# CITY OF ALBUQUERQUE

September 29, 2023

**Re: 224 Muriel  
224 Muriel Rd. SE  
30-Day Temporary Certificate of Occupancy  
Transportation Development Final Inspection**  
Engineer's Stamp dated 08-05-19 (L21-D072)  
Certification dated XX-XX-XX

ENGINEER'S SEAL DAVID SOULE P.E. #14522	224 Muriel Road, S.E. TRAFFIC CONTROL LAYOUT Rio Grande Engineering 1606 CENTRAL AVENUE SE SUITE 201 ALBUQUERQUE, NM 87106 (505) 872-0999	DRAWN BY WCWJ DATE 7-17-19 2109061-LAYOUT-7-17-19 SHEET # JOB # 2109061
---	---	---

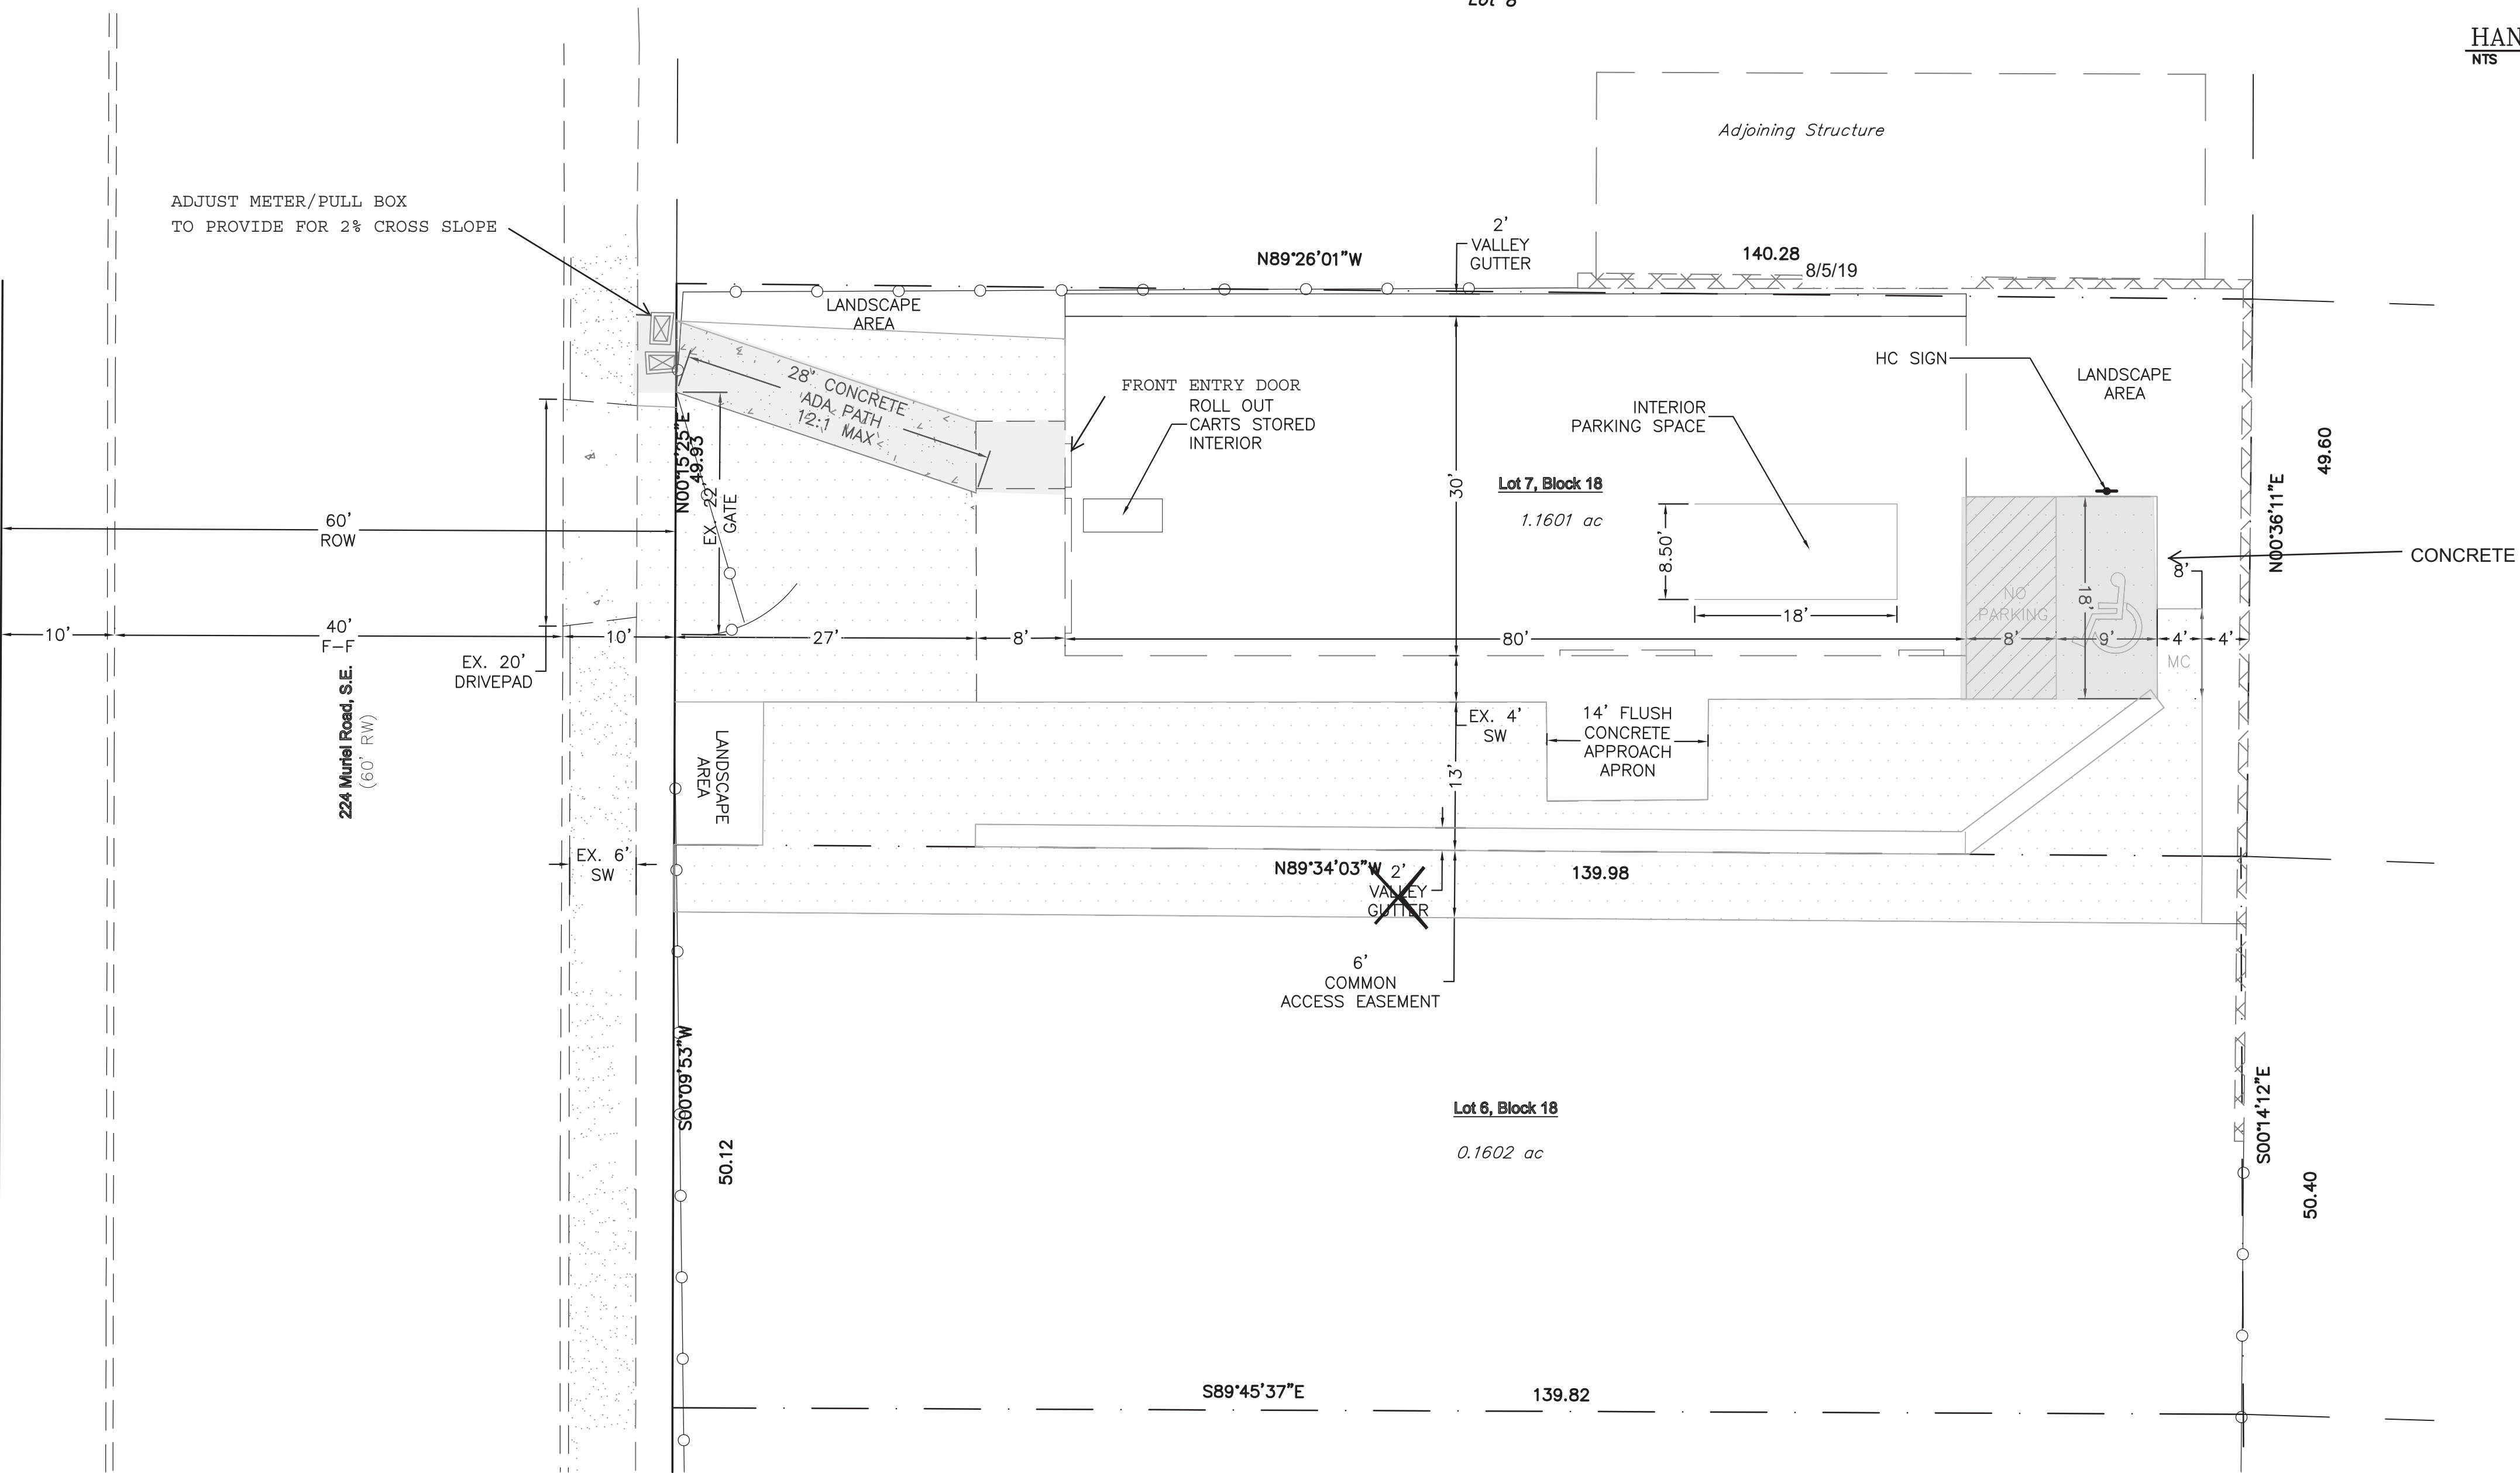
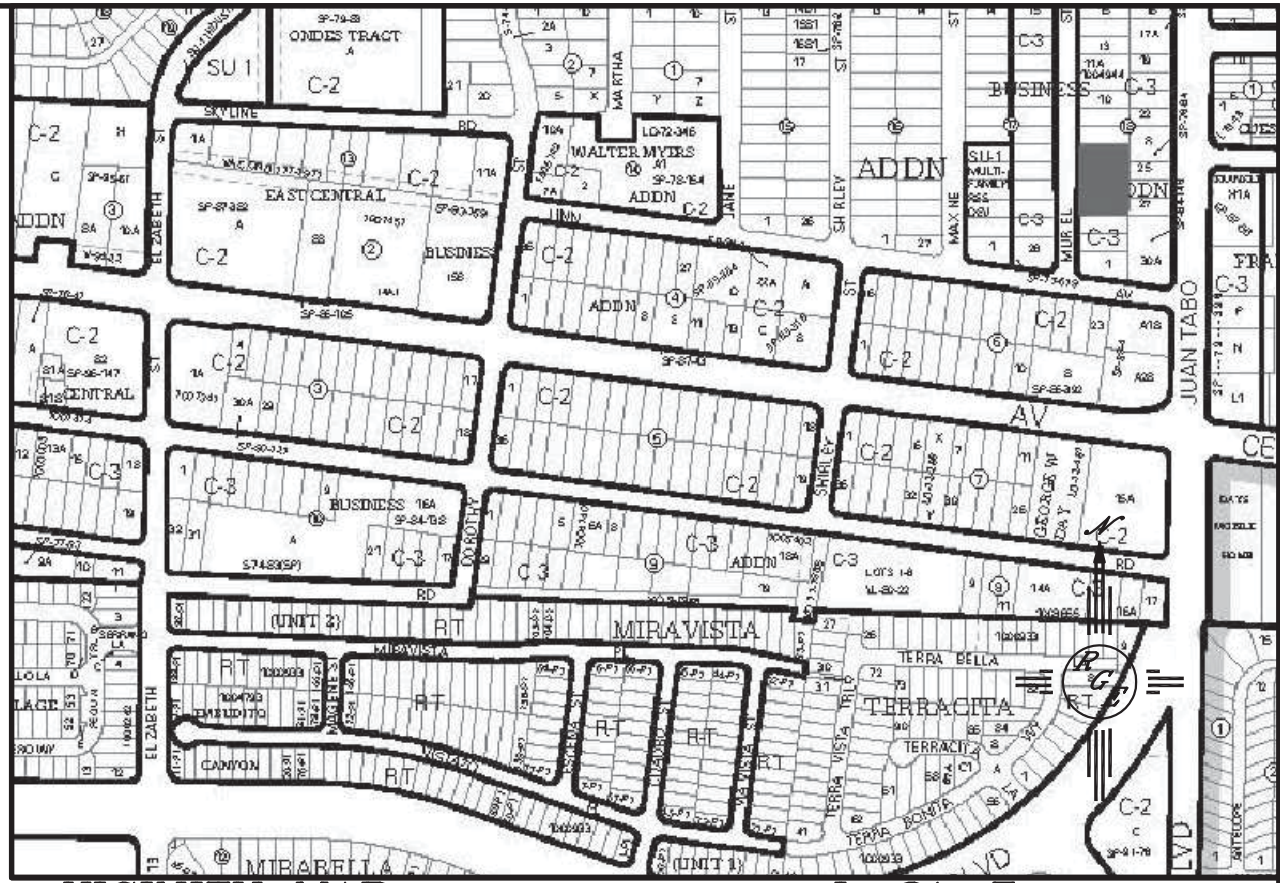
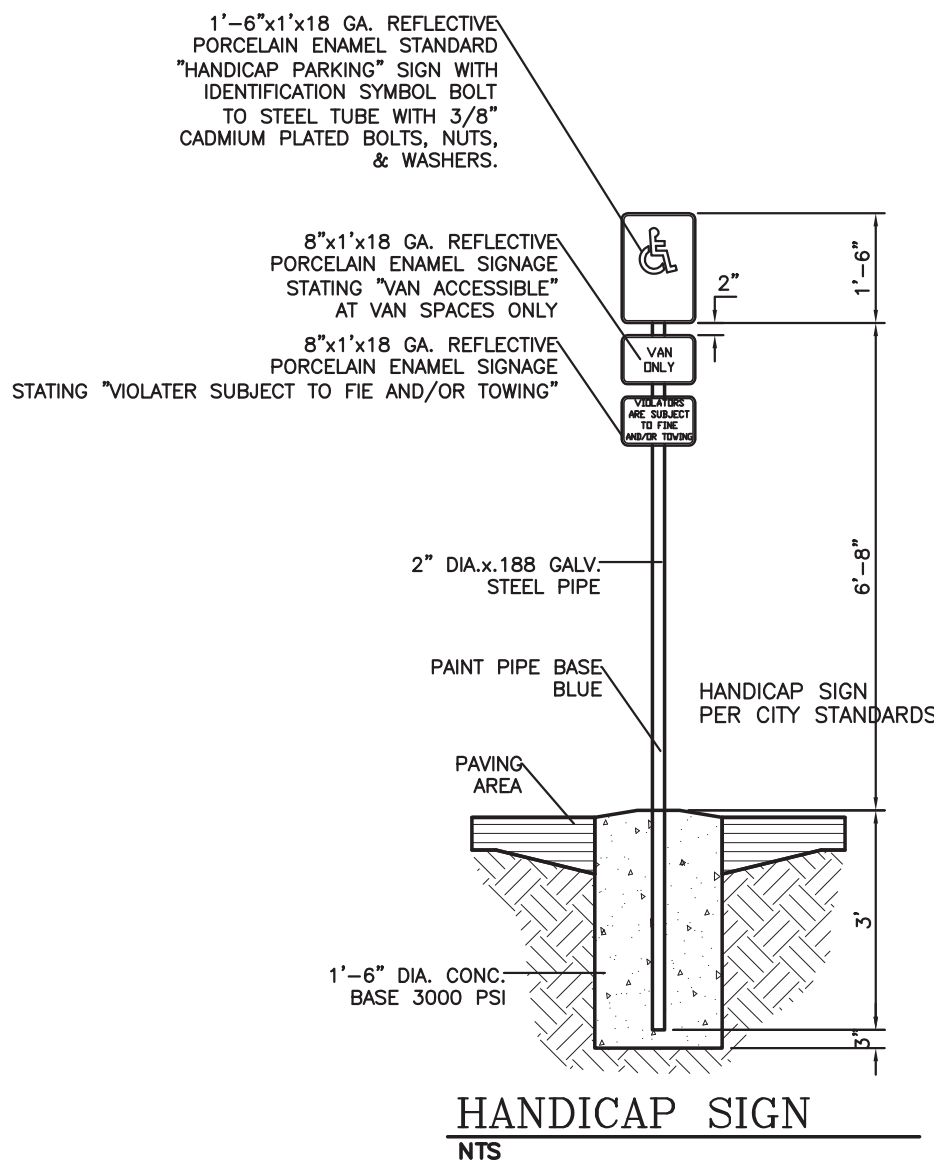
- Due to the locked gate during the site visit, please provide me with pictures of the ADA and Motorcycle parking spaces. These pictures should clearly display the dimensions and the signage in place.
- Per site visit, the pedestrian pathway from public sidewalk to the site gate is only 2 ft. wide. As a suggestion: please consider installing a 4'X4' concrete pad on the south side of the gate, to create an ADA compliant pathway.

- Please date your stamp on the Traffic Certification.
